Re: PA23-012 – English Crossing Townhomes – Technical Review 1

RE: English Crossing, File# PA23-012
247 New Townhomes
17406 19th Ave NE & Parcel # 31051900401200

To: Merle Ash, Land Technologies
From: Don McGhee, Assistant Fire Marshal
Date: June 1, 2023
Subject: PA23-012 English Crossing Townhomes 17406 19th Avenue NE

SUBJECT: PA23-012 English Crossing, April 2023 TIA & Technical Review #1

English Crossing  
 17404 19th Ave NE, Marysville, WA 98271  
 A PORTION OF SECTION 19, TOWNSHIP 31 NORTH, RANGE 05 EAST, W.M.

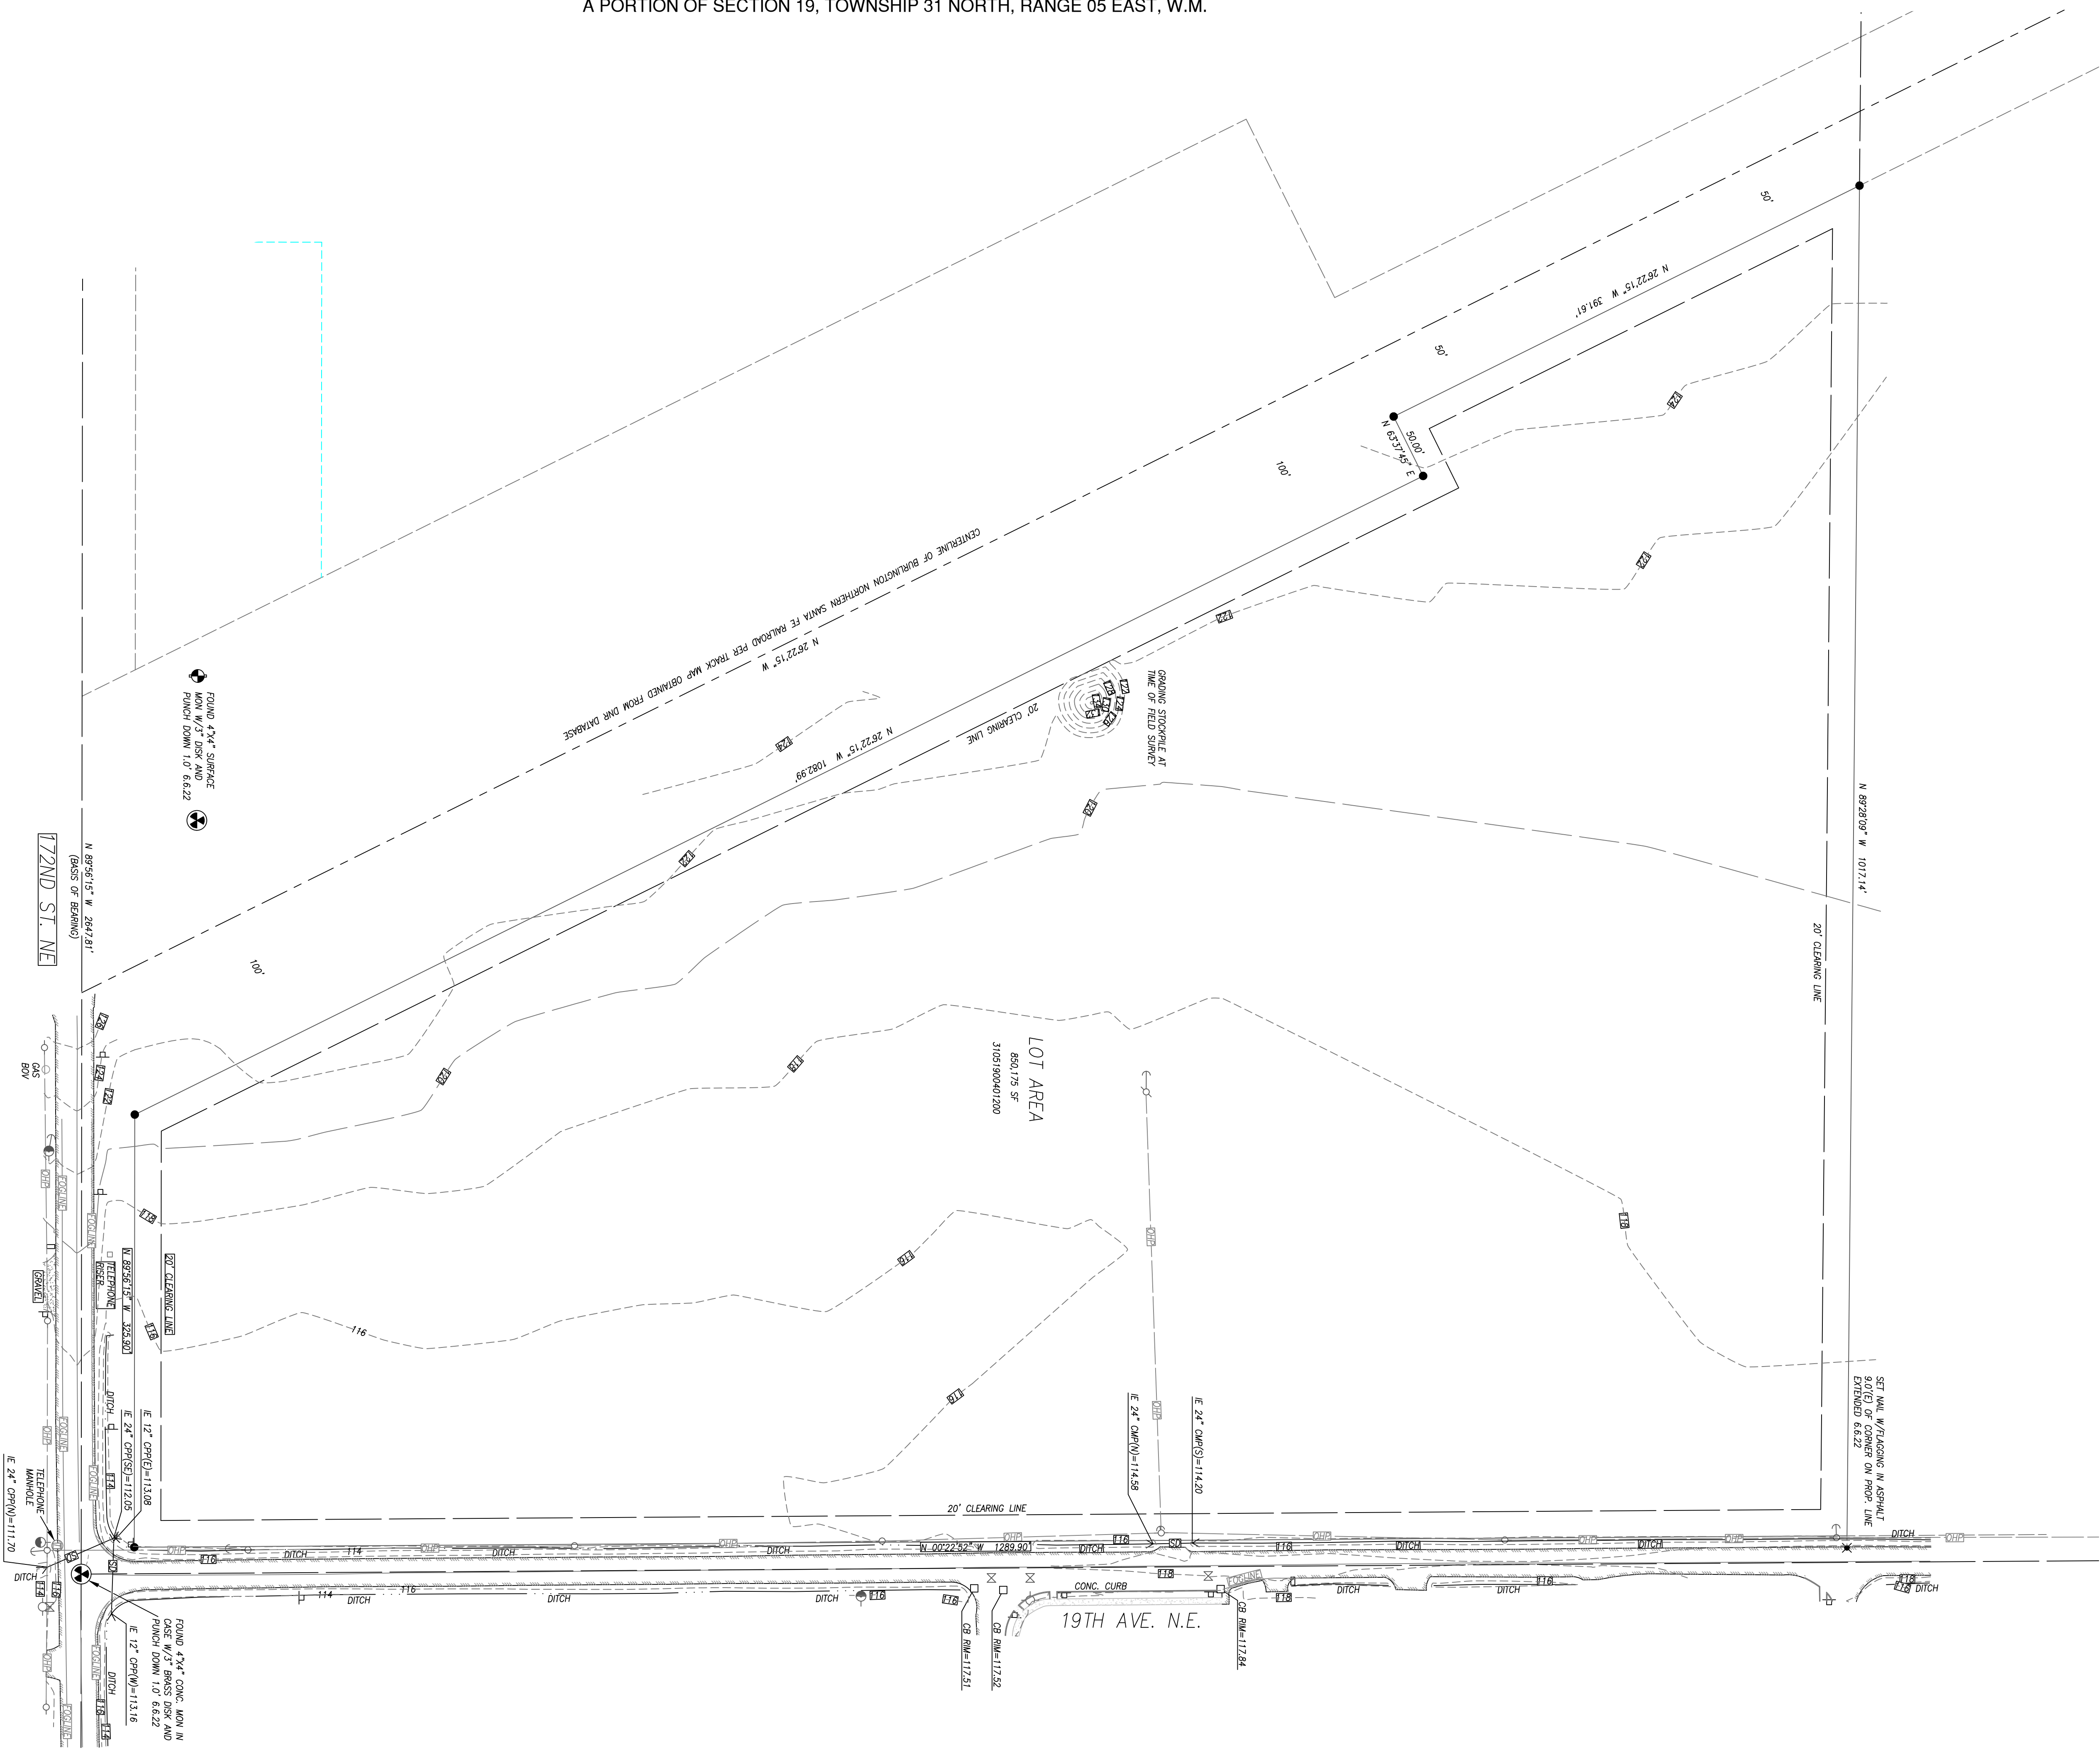
12. Consistent with [MMC 22C.065.120](#), fences adjacent to required common open space shall not exceed 4 feet in height.
13. Consistent with [MMC 22C.065.080](#), Townhouse open space, all townhouse developments shall provide at least 200 square feet of private open space per dwelling unit adjacent to, and accessible from, each dwelling unit. Please correct the reference on the site plan.

14. Staff has concerns with the biocells that have a 4-5 foot grade change from the edge of unit yards (see units 93-103 as an example). These areas do not appear to be accessible. Is it possible to add access point with stairs or a more gradual slope into the area?

18. Consistent with [MMC 22C.065.130](#), Street Connectivity, new development in the mixed use zones shall provide an integrated and connected network of streets to provide "direct" walking route options, orientation, a sense of place, and multiple travel route options. Blocks shall be designed to provide vehicular connections at intervals no greater than 600 feet and pedestrian access at intervals no greater than 300 feet (200 feet is preferred). Additional pedestrian access points are needed on Aisle C and Aisle F, as well as from Aisle H to 19th Avenue.

22. Applicant shall demonstrate how units 208-210, 107-109, and 213 can safely back out of the driveway without conflicts with the proposed medians.
